CITY OF ALBUQUERQUE

July 16, 2008

Re: Duke City Fueling Grading and Drainage Plan
Engineer's Stamp dated 6-24-08 (K10/D028)

**DUKE CITY FUELING STATION
GRADING PLAN**

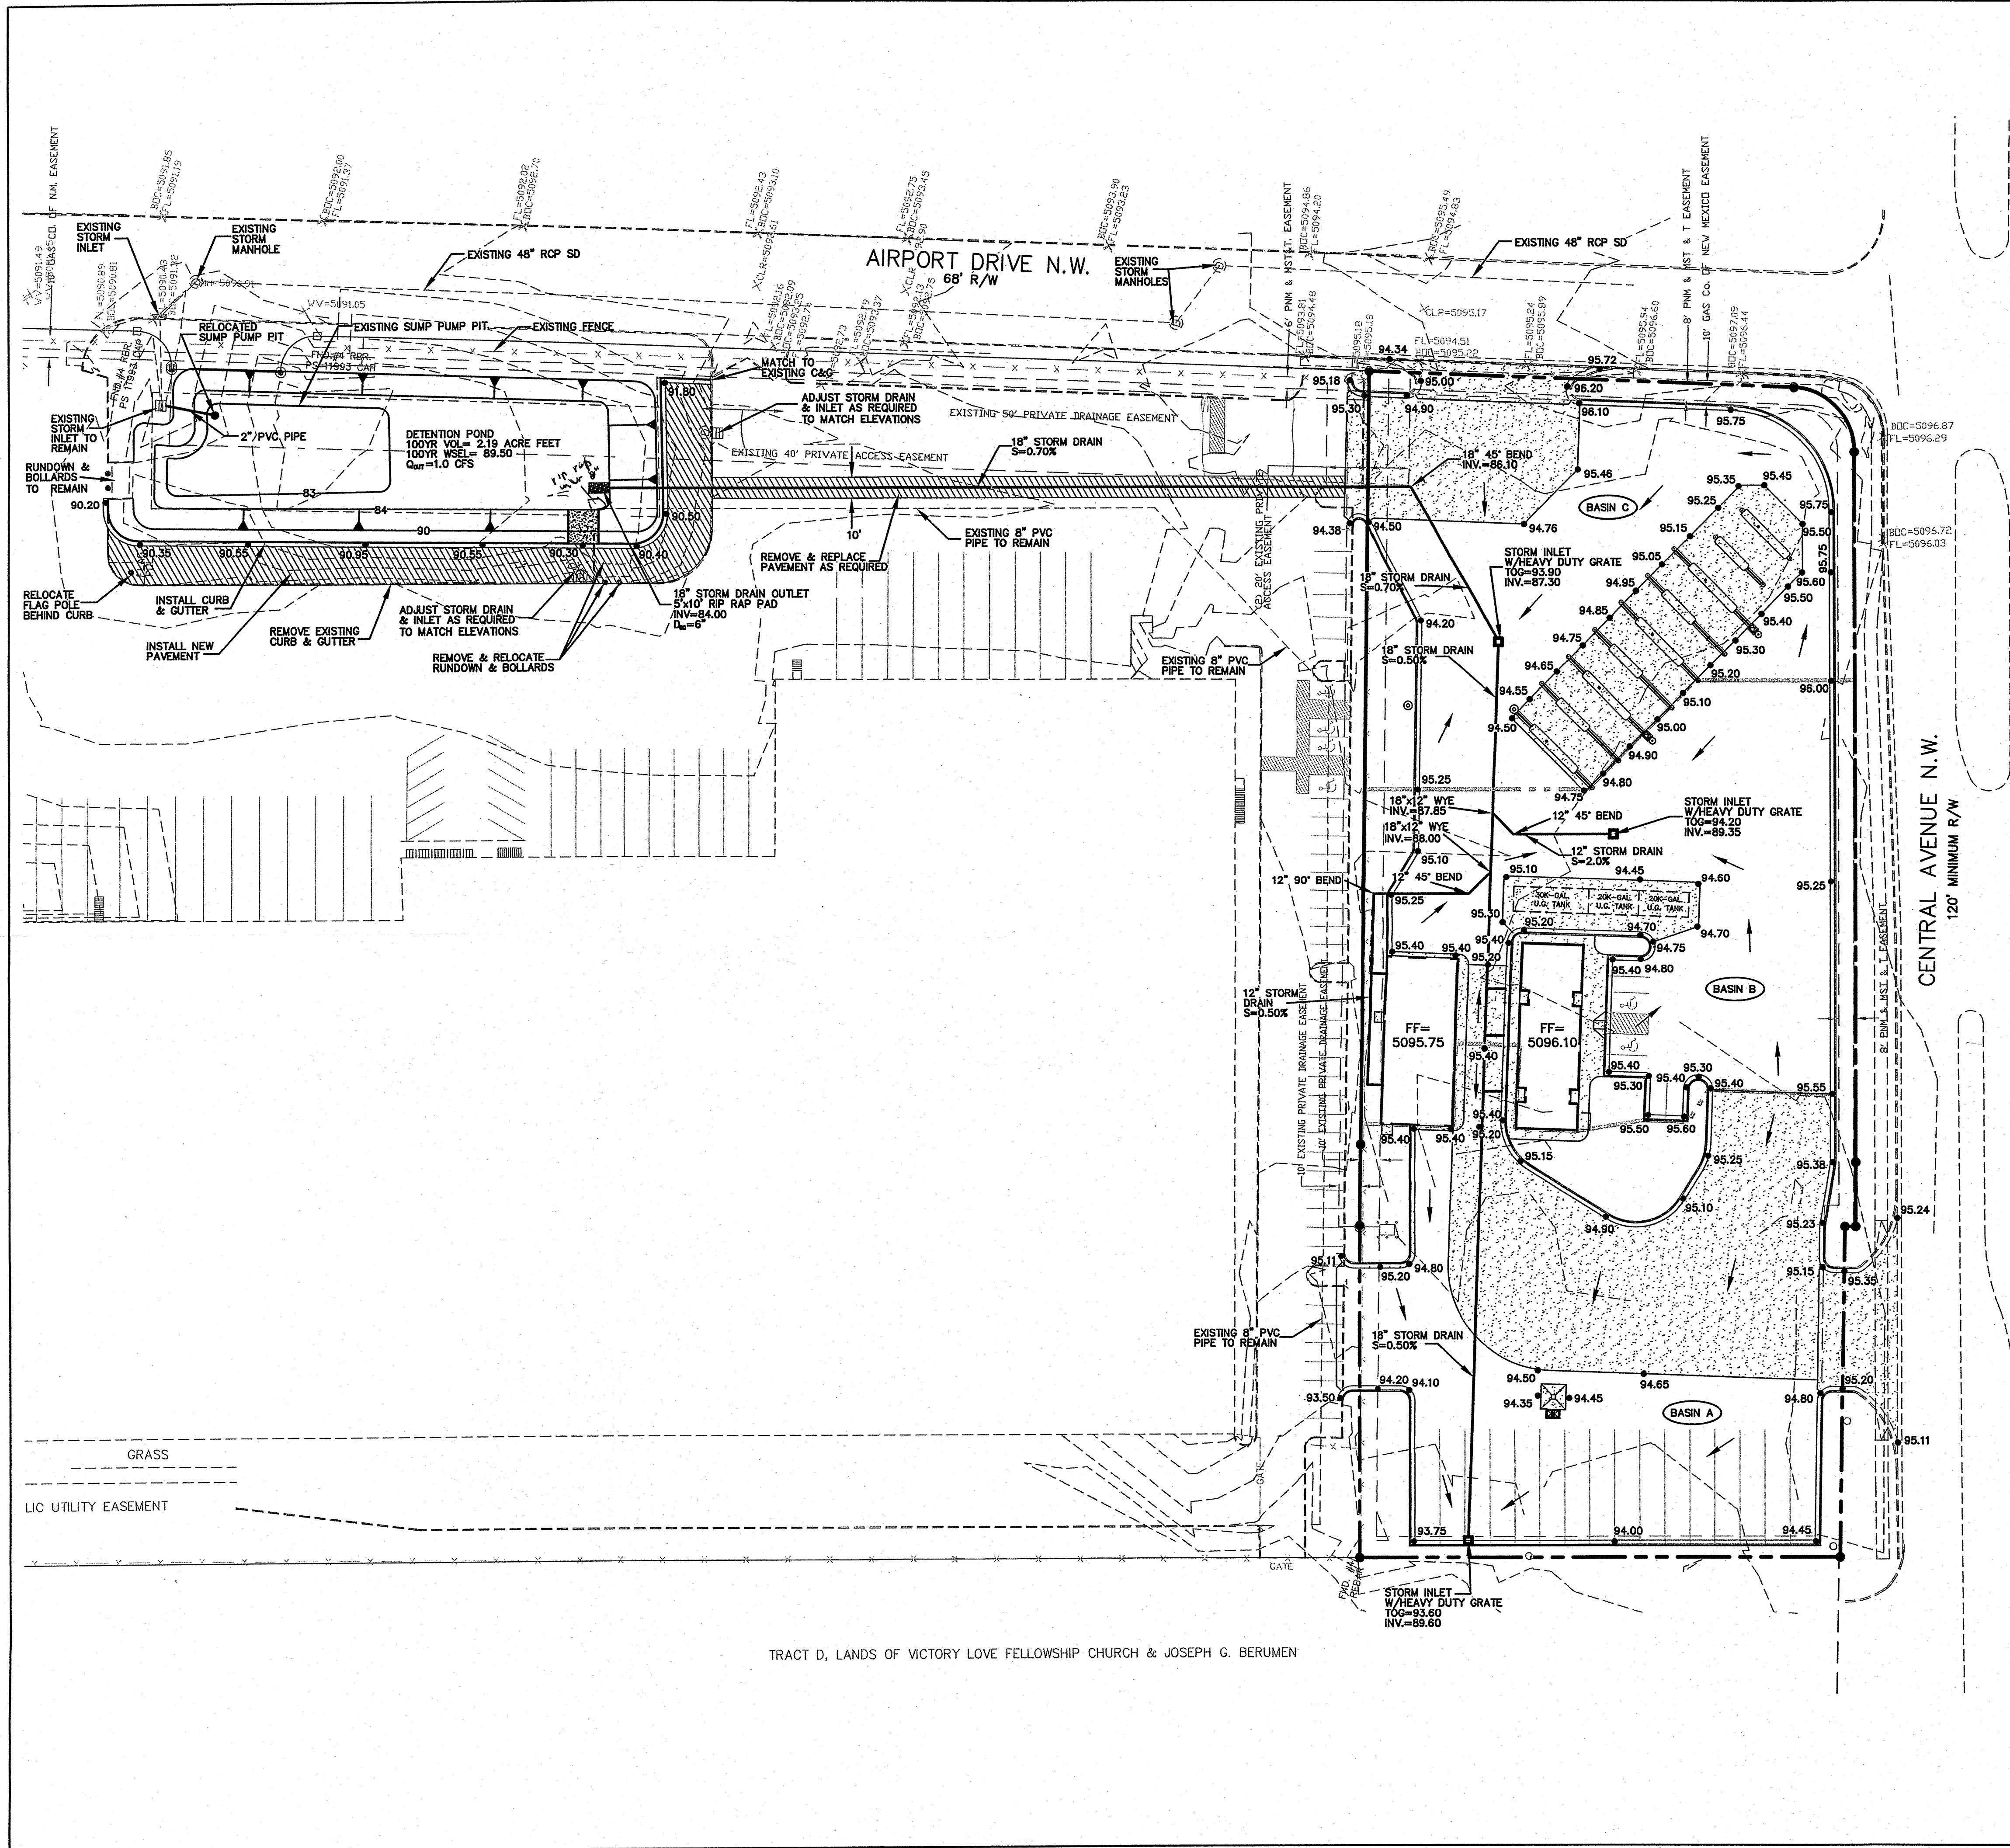
Per our discussion 7-16-08, rip-rap will be added at the outlet of the existing 8-inch storm drain from the adjacent site. Show this addition on the as-built plan.
